FAO: Planning Department,
Welwyn Hatfield Borough Council

Ref: 6/2024/0164/FULL
Date: 26/02/2024

HISTORIC BUILDINGS AND CONSERVATION ADVICE

RE: *The Howard Centre Units 28-29 Howardsgate Welwyn Garden City AL8 6HA*

2 EXISTING ELEVATION
Scale: 1:100

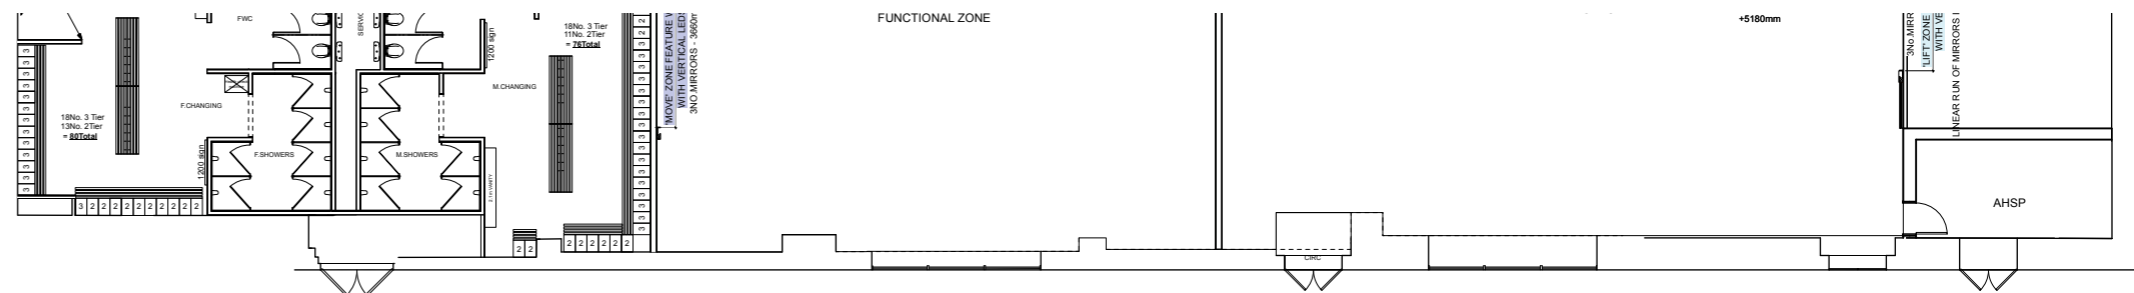
The proposed alterations would be contained to the rear (east elevation) of unit 28-29 which faces onto the train station/ tracks and is more utilitarian in appearance. There are limited views of the east elevation. The proposed changes are minor; the most notable change to the to the elevation is the existing door being replaced by a full height louvered panel. The proposal would not adversely impact the character and appearance of the Conservation Area. I recommend that a condition is attached requiring the type and colour of the new full height louver.
